November 5, 1986

RE: REVISED DRAINAGE PLAN FOR CENTRAL COMPOUND (K-15/D37)  
1604 - 1608 CENTRAL AVENUE, SE RECEIVED NOVEMBER 5, 1986

October 31, 1986

RE: REVISED DRAINAGE PLAN FOR CENTRAL COMPOUND (K-15/D37)  
RECEIVED OCTOBER 22, 1986

SITE PLAN / DRAINAGE PLAN

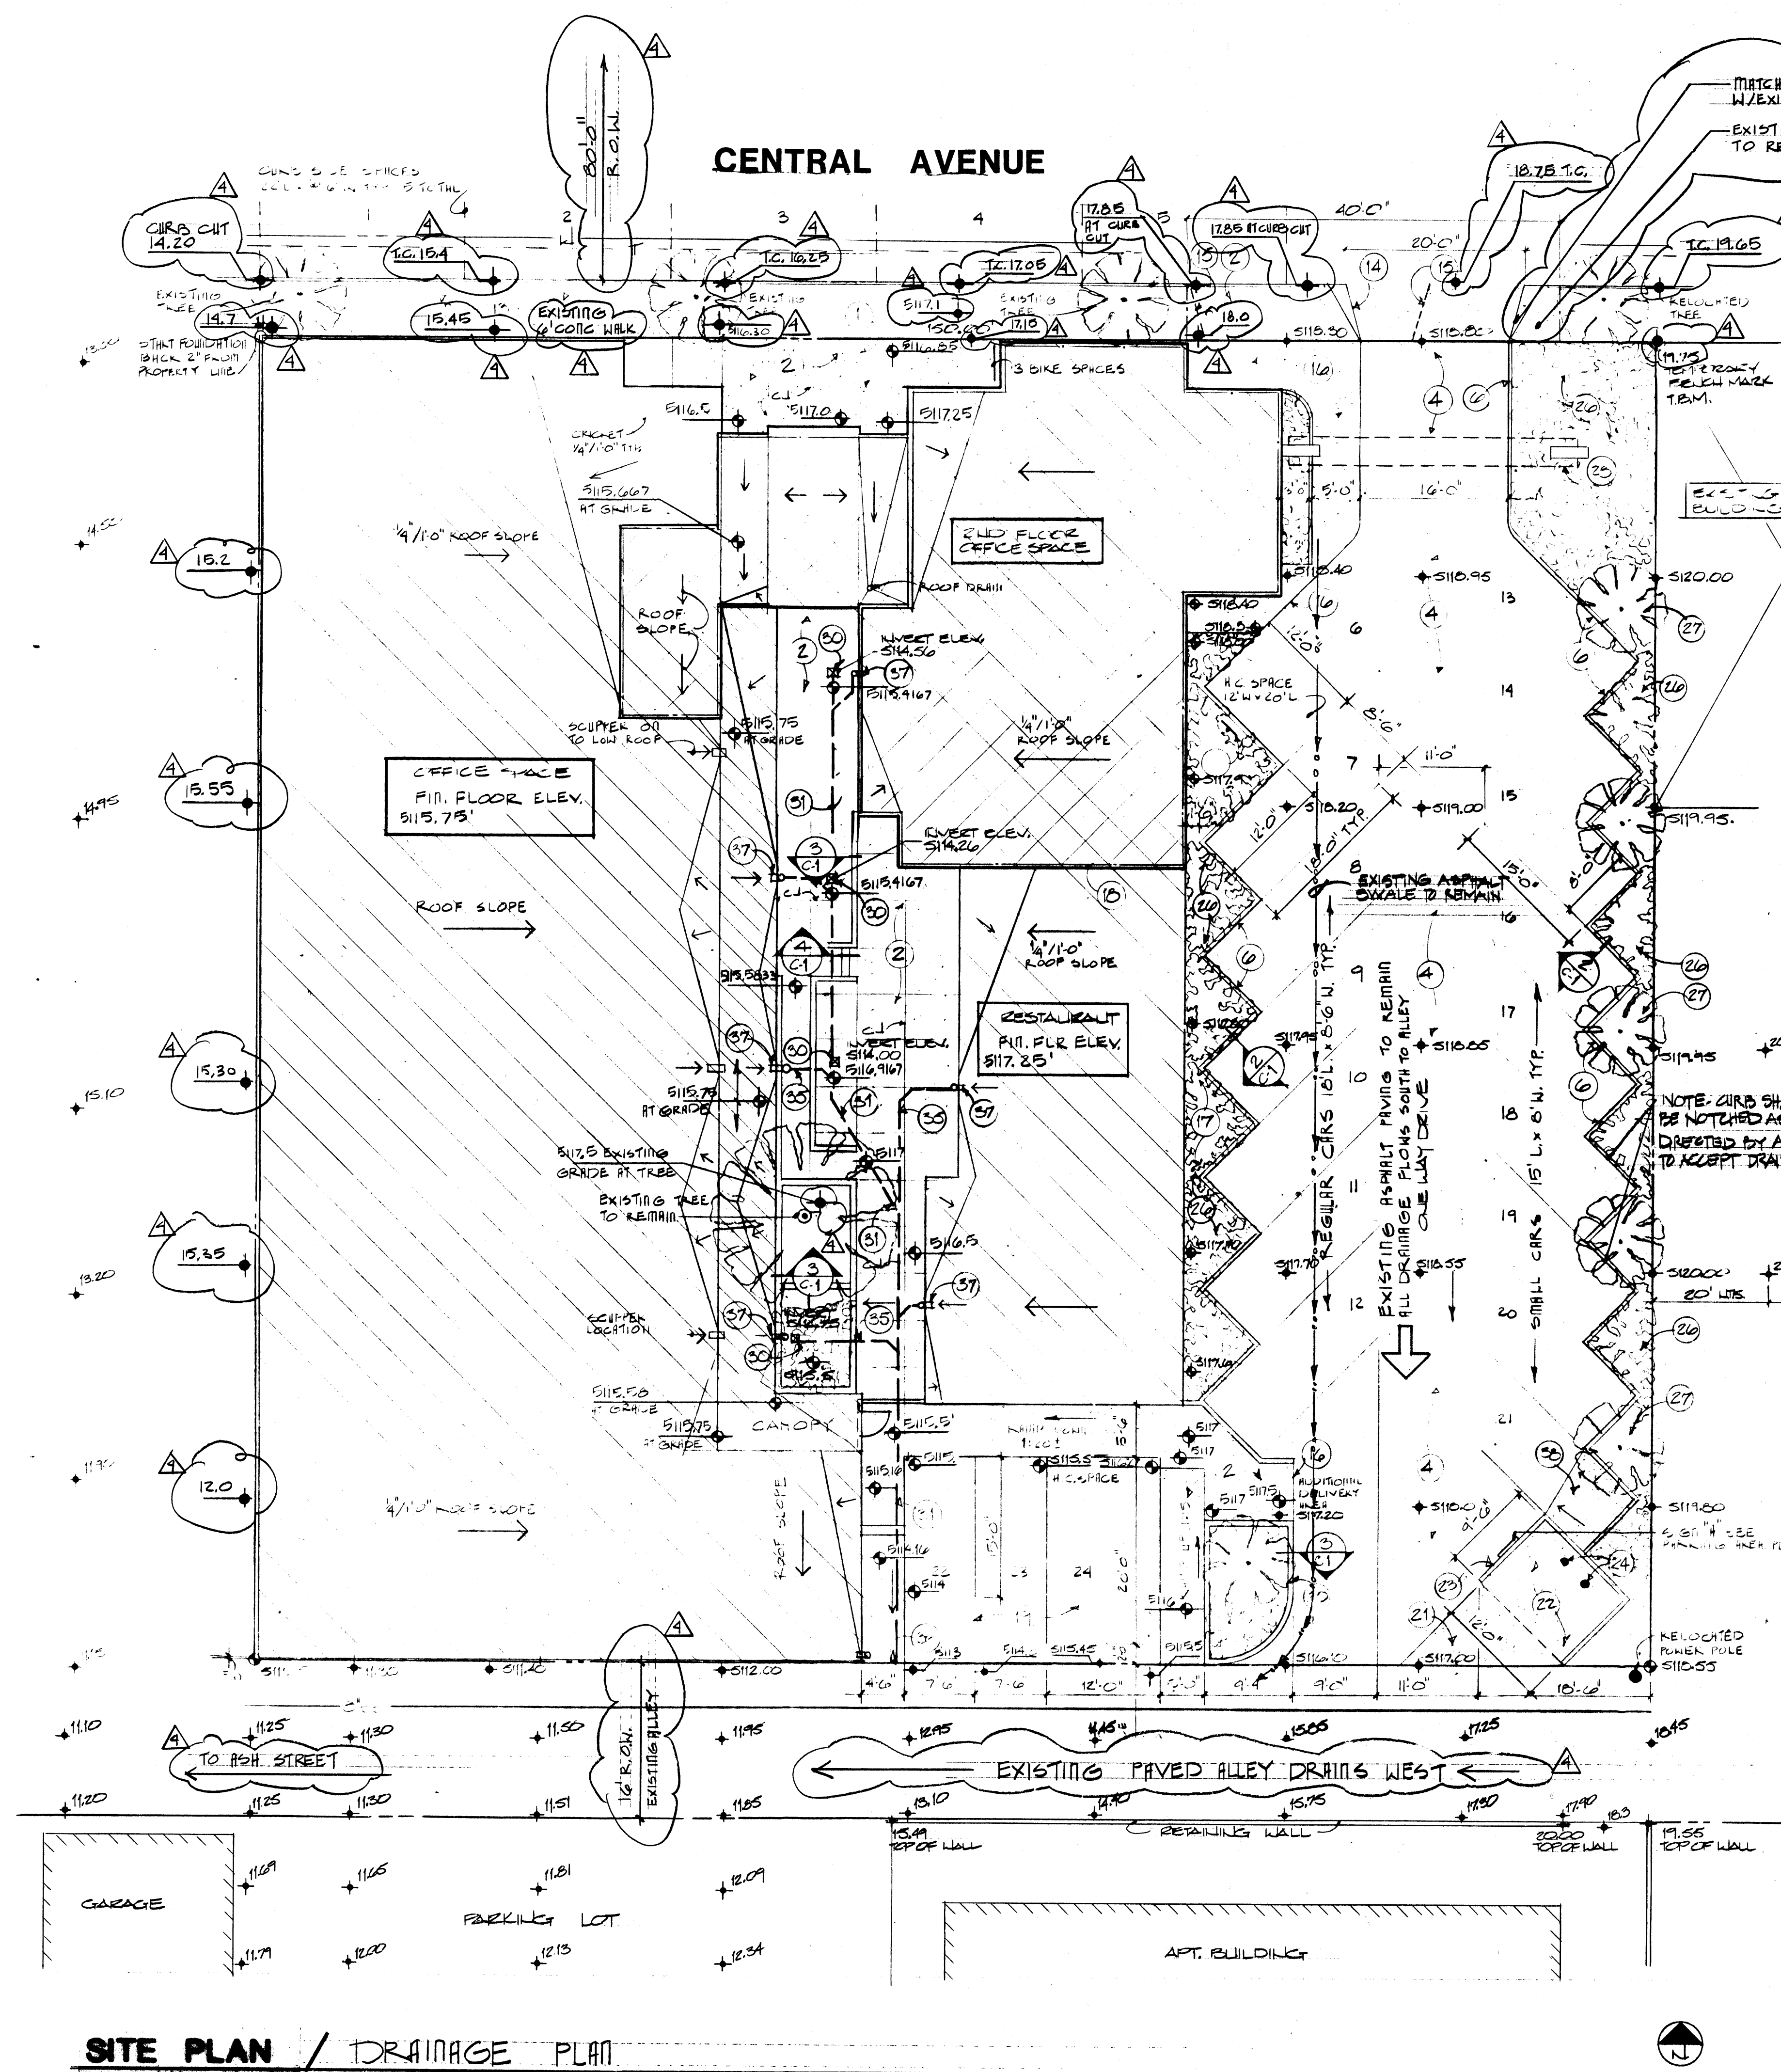
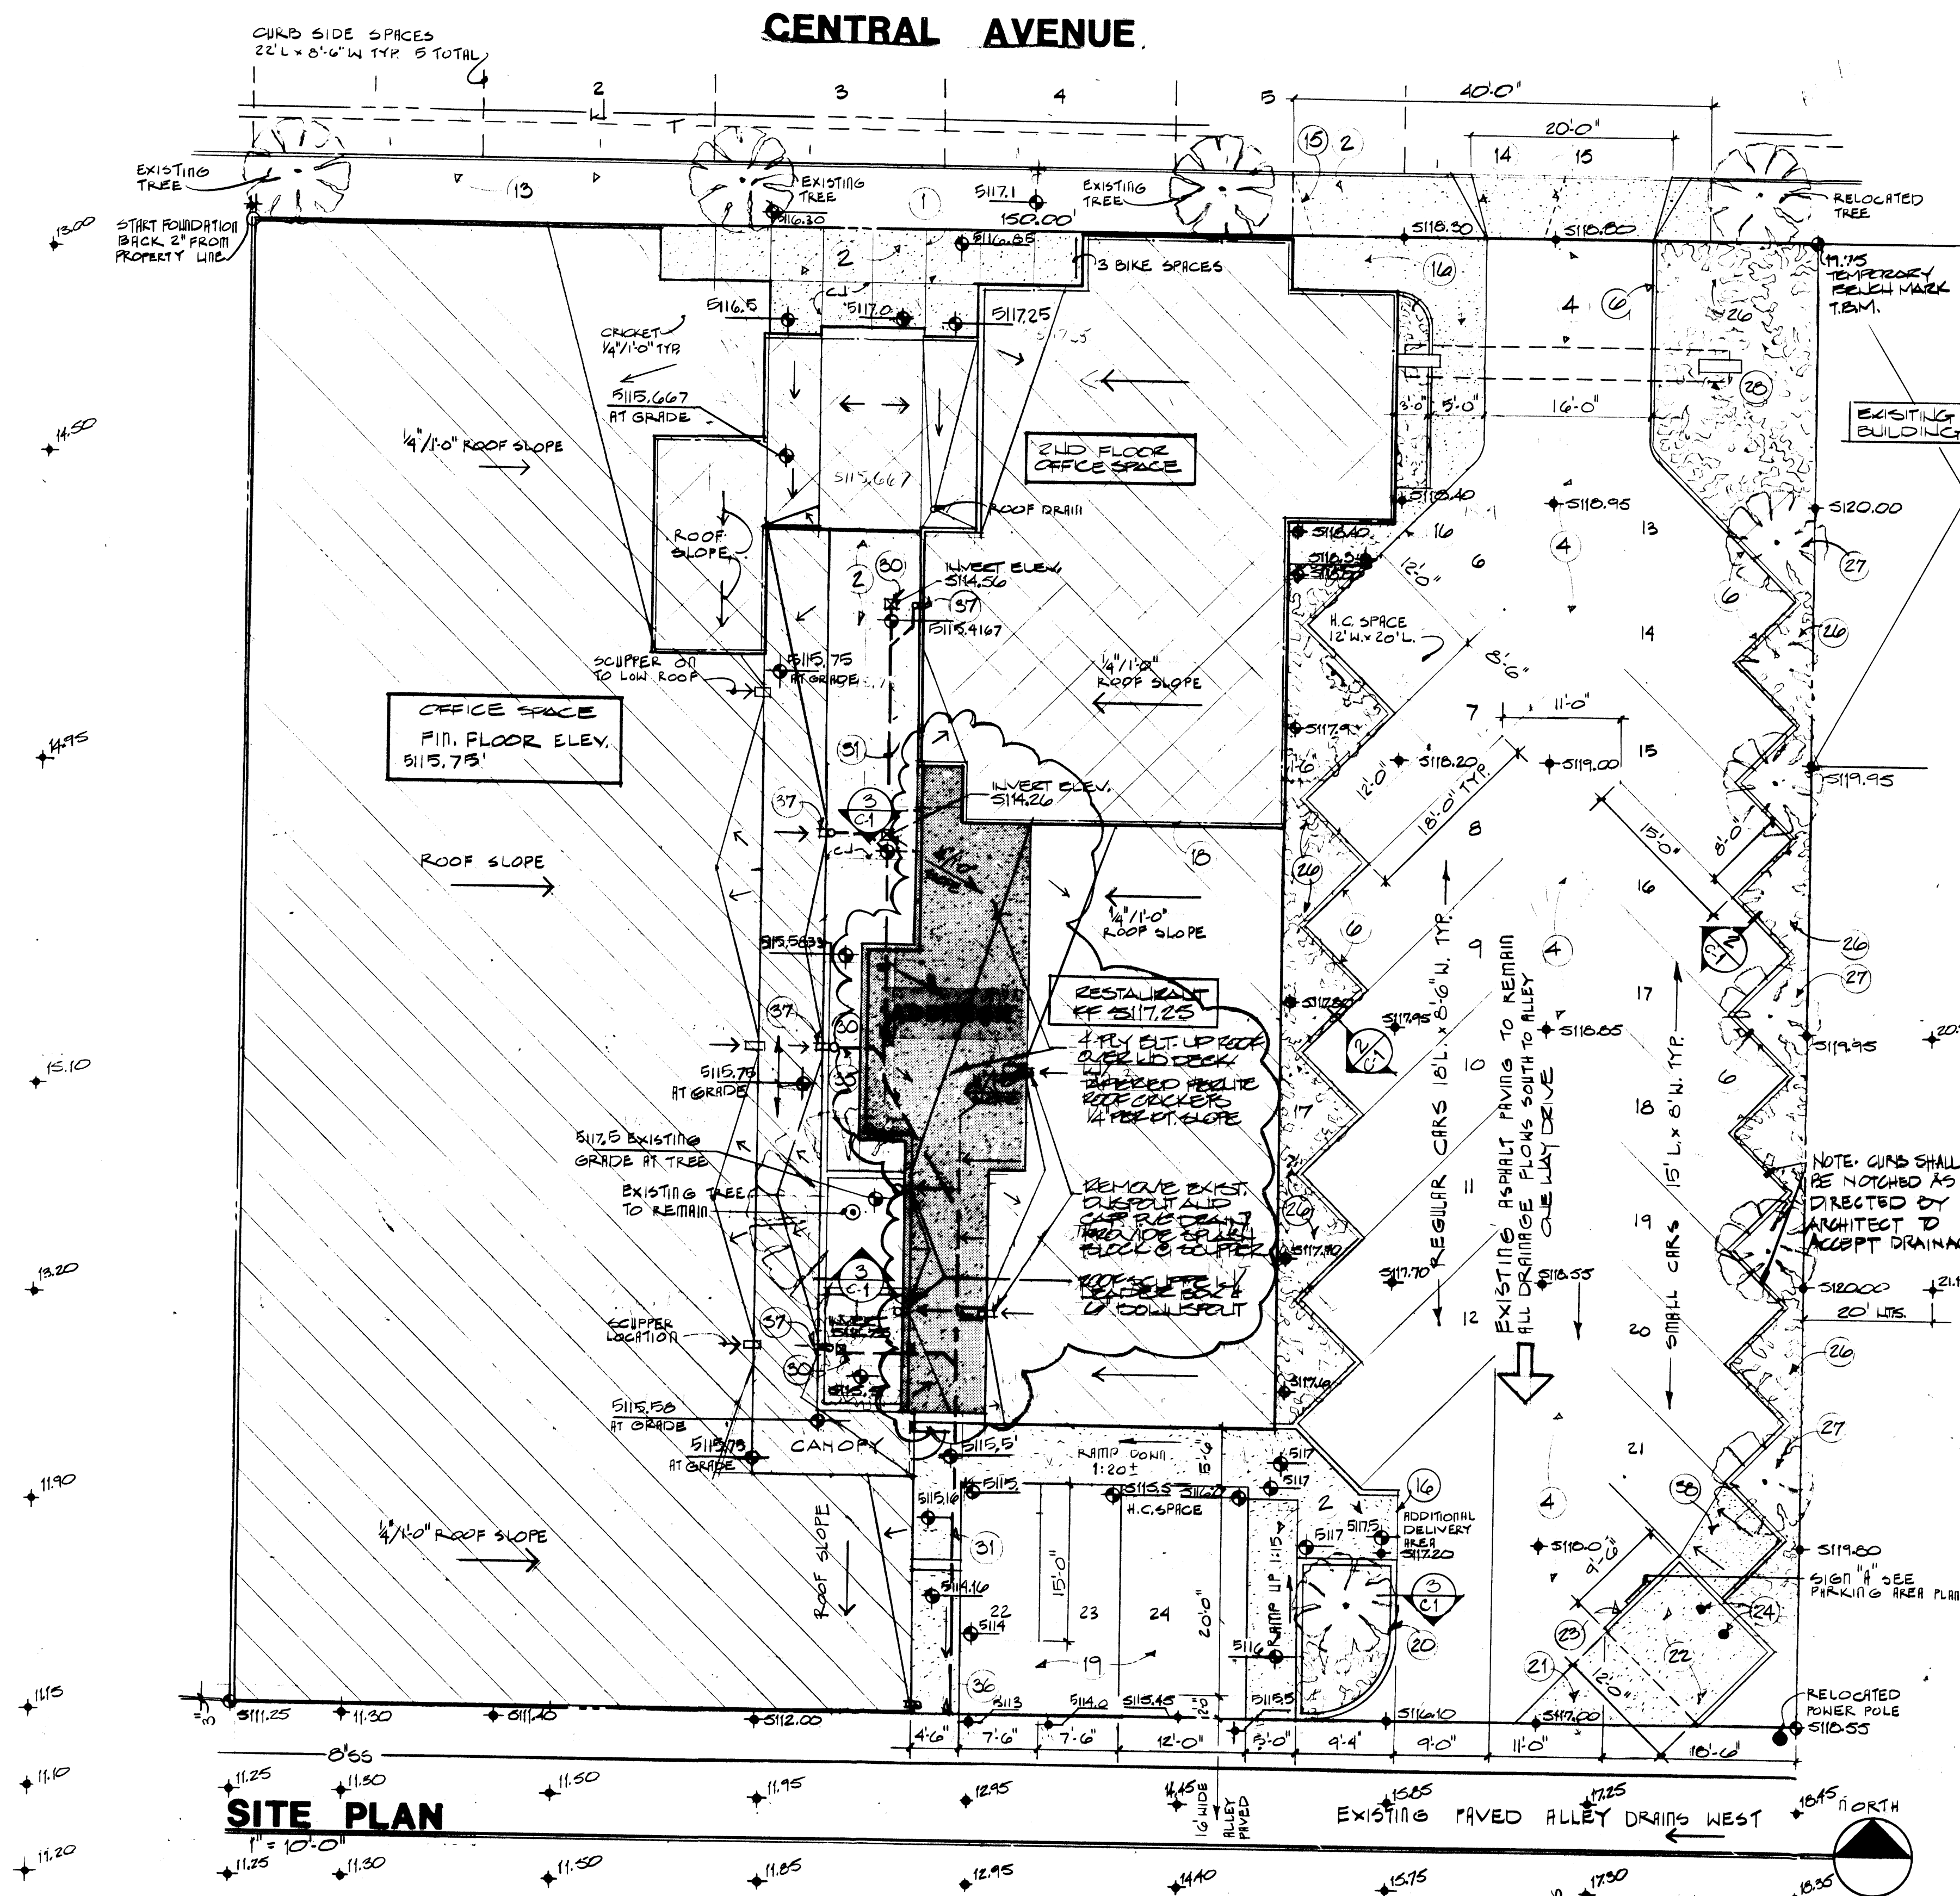
1. The plan submitted is not very clear and is rather difficult to review. *ok*
2. The hydraulics for the swale should be provided. *No new construction*

3. It appears as though the buildings and the internal courtyard are to be drained by some enclosed system. Please provide the necessary hydraulics and details for this system to show that it will work. Also, downstream capacity has not been addressed or quantified. *on plan weir provided if plugged.*

4. The off-site area in the vicinity of the southwest corner of the property appears to pond water based on the elevations shown. The drainage scheme for the site discharges to this area and cannot be allowed. Also, easements will be required for discharge onto adjacent property. If it is supposed to be an alley, it is not identified. *This area is an existing alley that drains west.*

5. What is the purpose of the notches in the curbs in the parking area? *To receive off-site flows See note on plan*
6. The plan does not have a legend per DPM standards. *ok*

7. The off-site structures do not have finished floor elevations. All structures within 25 feet of the property line are to have the complete MSL for the finished floor.

8. All easements and rights-of-way with dimensions and purpose are to be shown.

9. Existing City top of curb and flowline elevation need to be provided.

10. Required spot elevations for the standard City drivepad need to be provided.
